From: John Green
Sent: 30 October 2012 12:04
To: Susan Leeson
Cc: Planningecons; Graham Evans
Subject: RE: EG/59/12

I have viewed EG/59/12 and make the following comments:

TITLE SITE PLAN

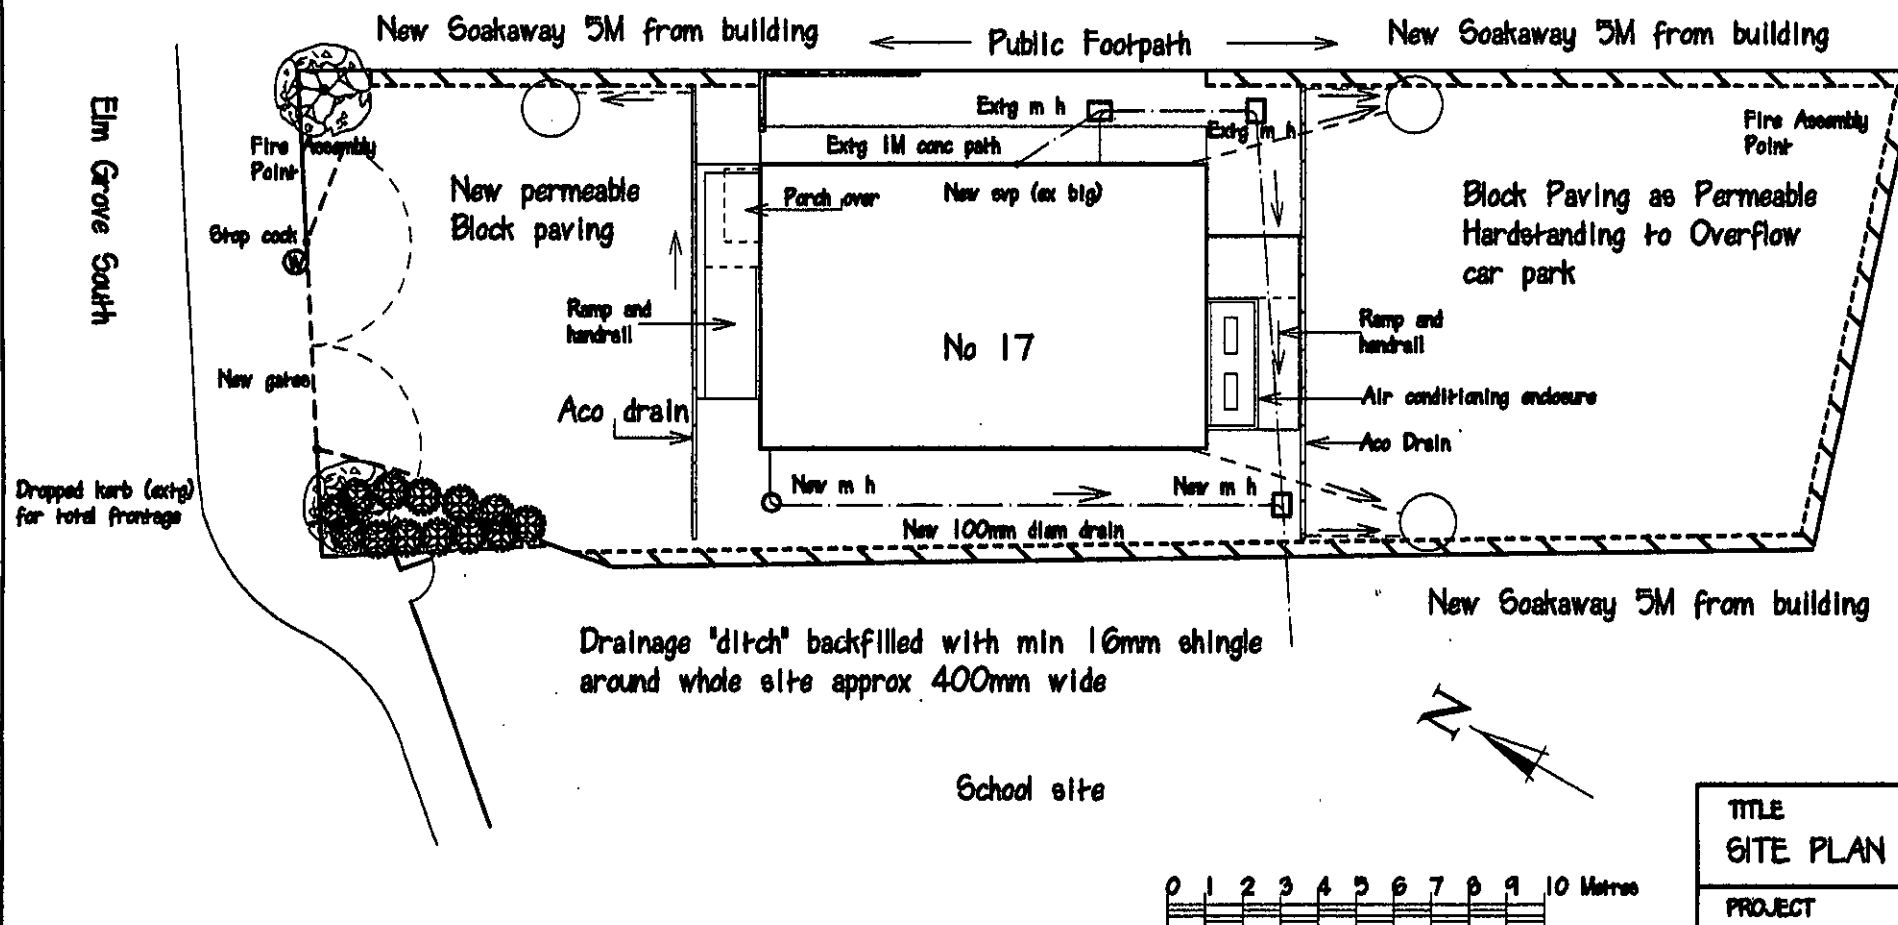
There is potential for noise affecting nearby residential premises. The information provided on sound power levels gives 3 sets of sound data, the first of which is significantly louder than the second two. It is unclear when the first set of sound power levels applies and under what circumstances. I would therefore object to the application unless further clarification is provided. I note that the fence surrounding the a/c units is described as "hit and miss" and I therefore assume that this will have gaps and thus offer negligible noise reduction.
